Ref: EN010163 - Response from NCC

Steeple Renewables Project

With regard to the recent request for comments relating to additional information dated the 25th August 2026, NCC have the following comments to make.

P22-1144\_EN\_27\_A\_04

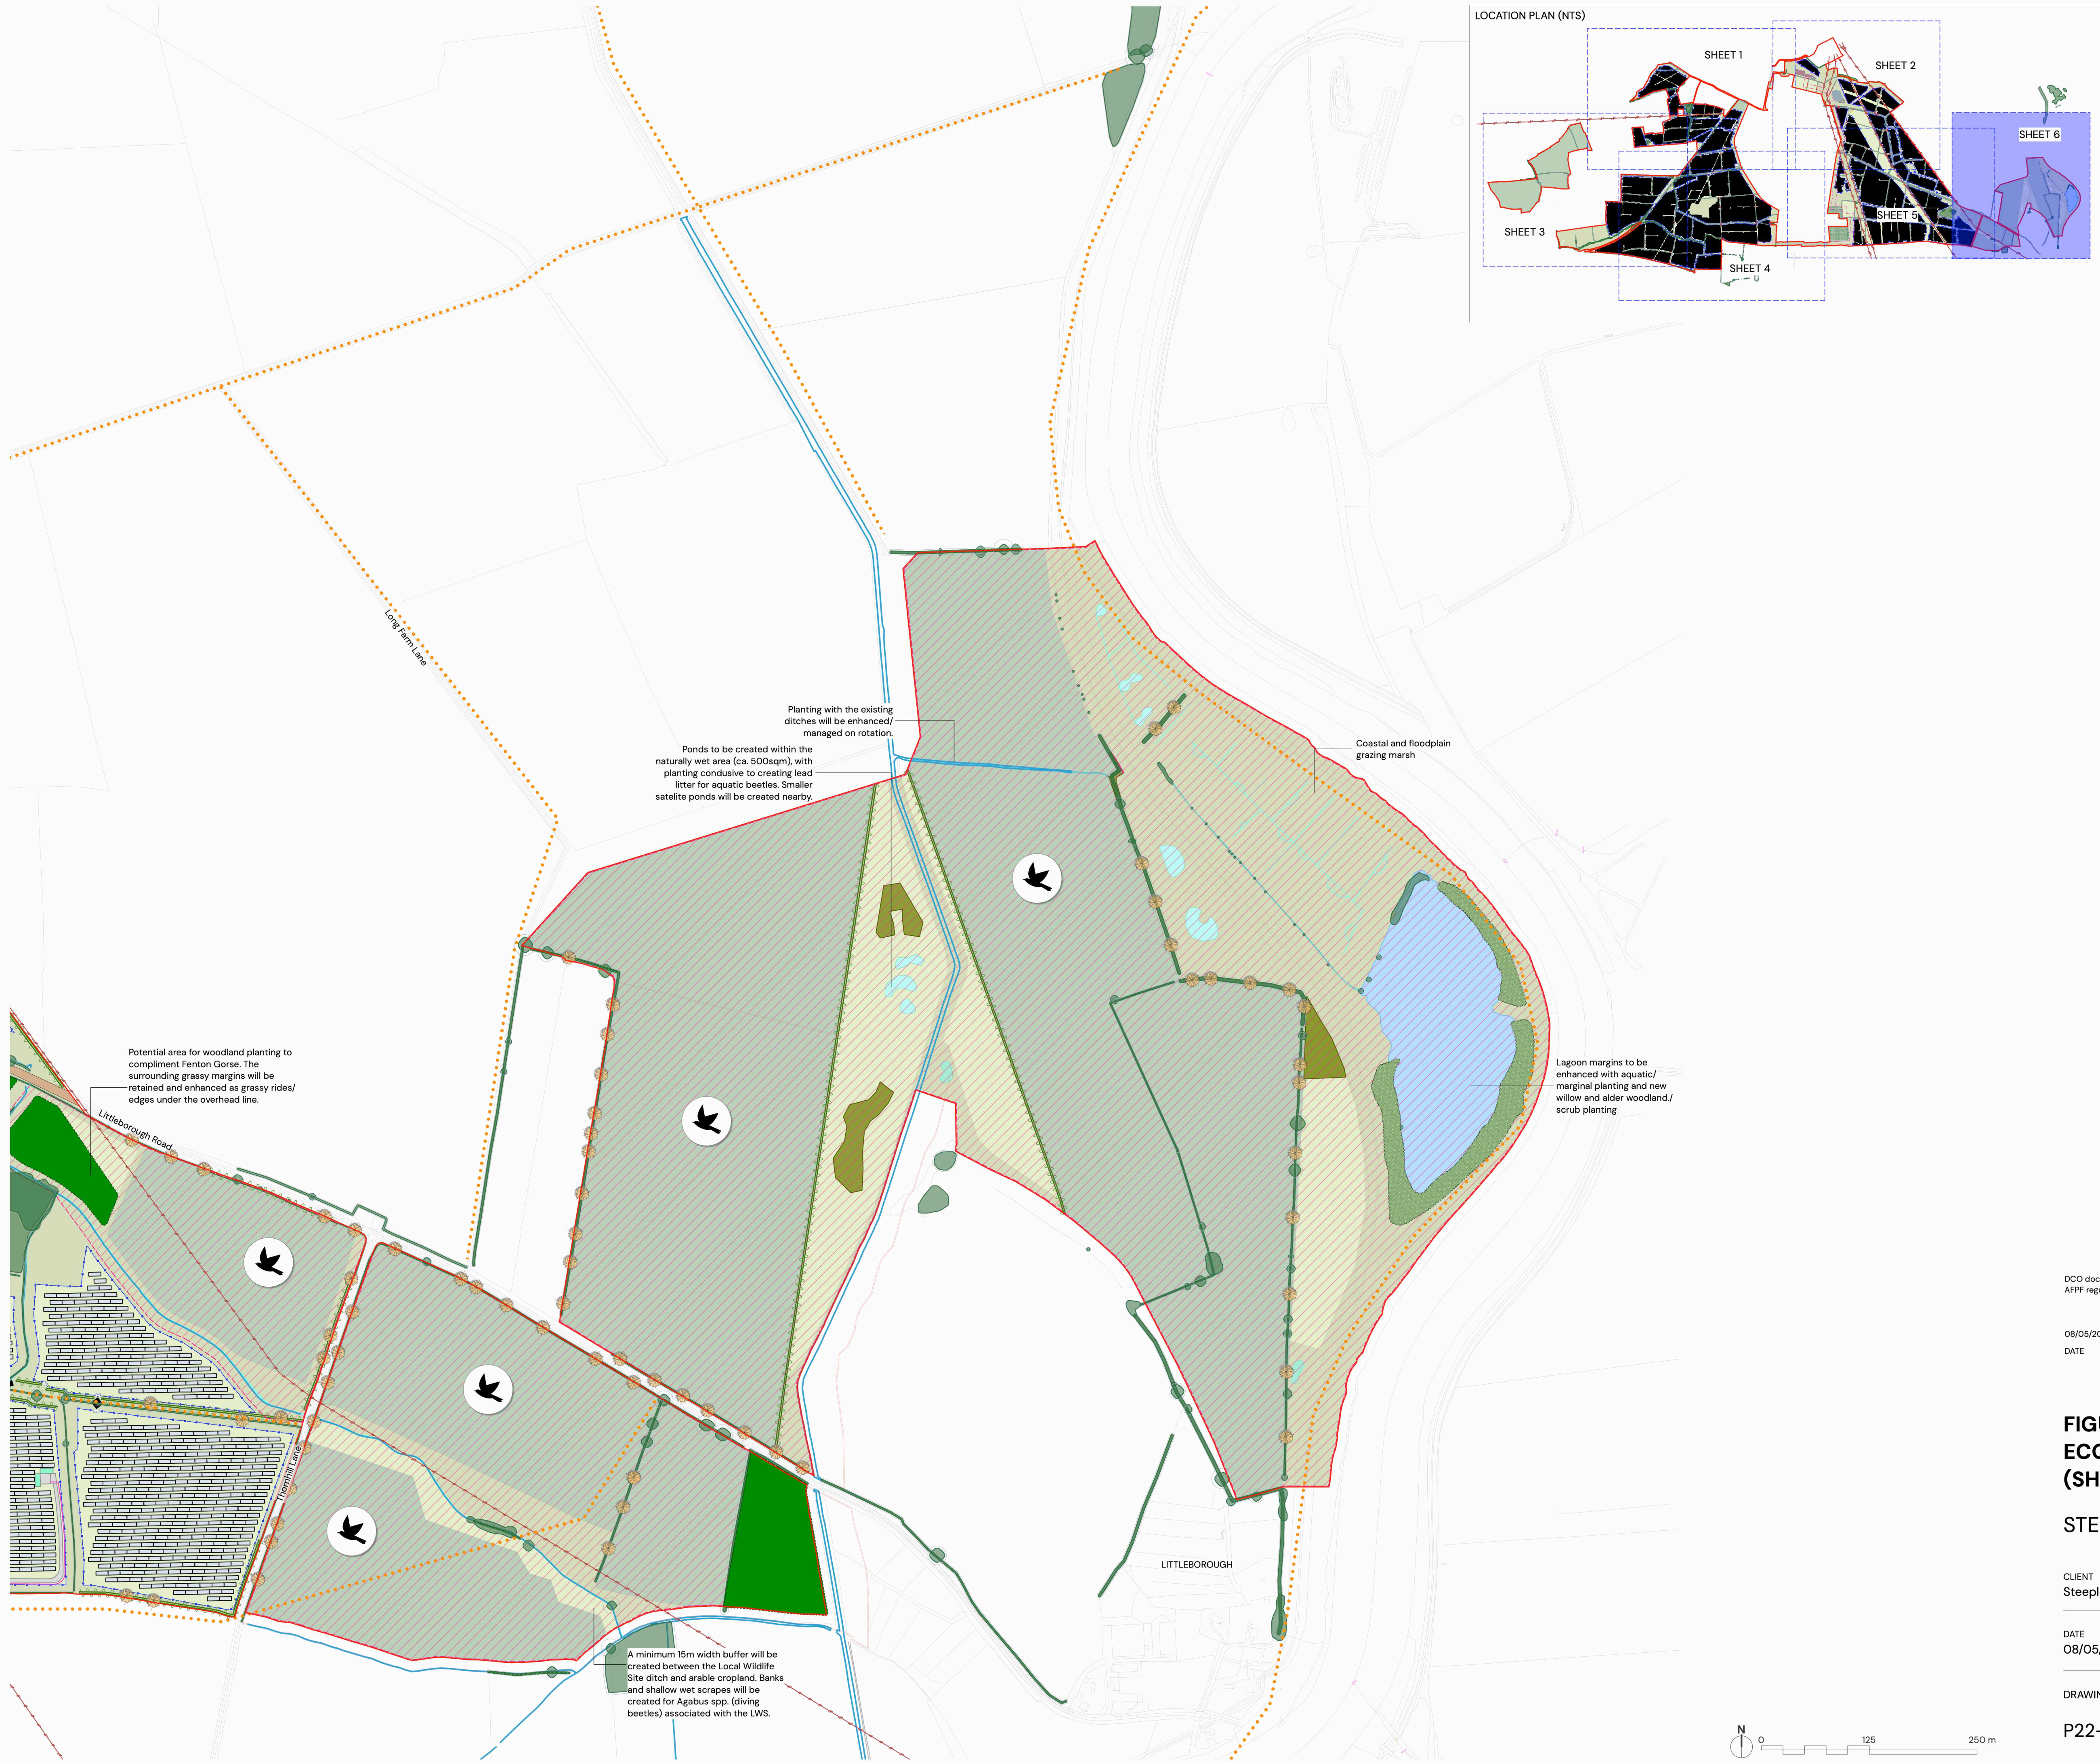
The additional native hedgerow proposed to the western side of the BESS is welcomed and is considered to provide an appropriate additional layer of landscape mitigation. Its location close to the BESS compound should assist in filtering and softening views of the perimeter infrastructure in combination with existing and previously proposed vegetation.

It is agreed that the additional planting is unlikely to result in a change to the significance conclusions reported within the ES. However, it would be more accurate to recognise that the planting is expected to provide a slight further reduction in the degree of visual effect as it establishes, notwithstanding that this would ultimately not alter the reported significance judgement.

The final LEMP should clearly identify the additional hedgerow and provide an appropriate planting specification including species composition, planting density, establishment and management proposals and intended management height and width. I note that existing and enhanced hedgerows are proposed to be maintained at approximately 2.5m in height and 1.5m in width. It should be confirmed whether these dimensions would also apply to newly created hedgerows once established.

The final arrangement should allow sufficient separation between the proposed hedgerow, Security fencing and BESS infrastructure to allow the planting to establish and be maintained effectively. NFCC guidance states that combustible vegetation should be at least 3m from BESS infrastructure; however, engagement with the local fire safety officer should be consulted to confirm that the proposed arrangement and offsets are acceptable from a fire safety perspective.

From a landscape perspective, sufficient space should also be provided for long term maintenance access, with a minimum 2m maintenance strip recommended. The mature extent of the hedgerow should also be maintained at least 3m from the security fencing to reduce the potential for established vegetation to provide a climbing aid and compromise site security. The Applicant could also consider incorporating suitable thorny native species within the final hedgerow mix to provide an additional degree of natural deterrence.
